GREENGORE, HILL LANE, HURST GREEN, CLITHEROE.
REPORT ON A PROPOSED ACCESS TRACK FOR AGRICULTURAL PURPOSES.

PLANNING REFERENCE 3/2021/0057

A G & P Jackson
Chartered Surveyors and Land Agents
Applethwaite House
Wetheral Pasture
Carlisle
CA4 8HR

February 2021

Greengore			
Prior Notice	JJ	Private Way	1:1250 scale
January 14 2020		Location Plan

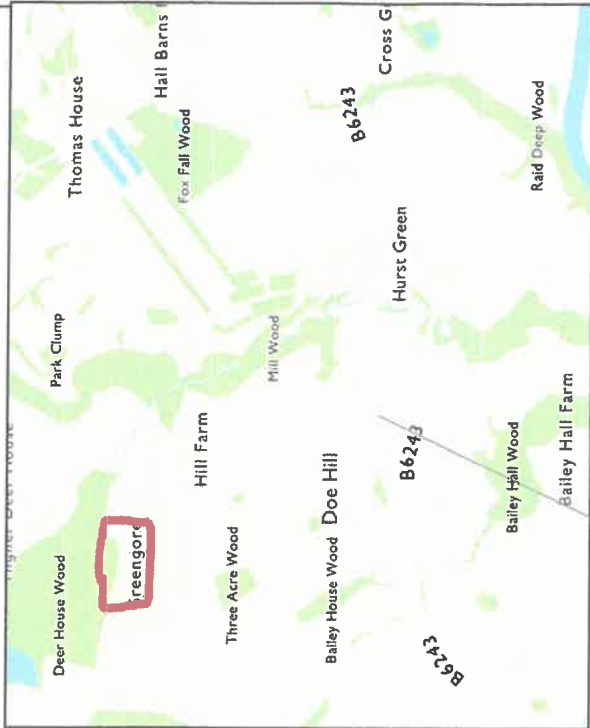
- 5.2 This track is to run through the tenanted land just inside the field boundary and then cross the owner occupied land to reach the northern gable of the former shippon.
- 5.3 It is to be 122 m long by 3.5m wide giving an area of 427m². It is to be constructed as a twin track with a grass centre from hard core with a porous surface. Mrs Johnson felt she would use the hard core from the demolished silage pit.

- 7.4 It would also appear that the section of the proposed track that runs immediately north of the gable end of the modern agricultural building does not fall within the tenanted area held by Mr Dewhurst. Therefore, this section of track may not fall within an area currently being used for agricultural purposes.

- 7.5 If you conclude that the application falls within Class B, I draw your attention to paragraph B.2 (f) which states that development is not permitted by Class B if any part of the development would be carried out within 5 m of any boundary of the unit. In this case the proposed track follows the boundary of the applicants 2.8 ha agricultural unit and is within 5 m of it

Greengore Private Road may not be within the agricultural tenancy held by Mr Dewhurst and therefore may not be in use for agriculture.
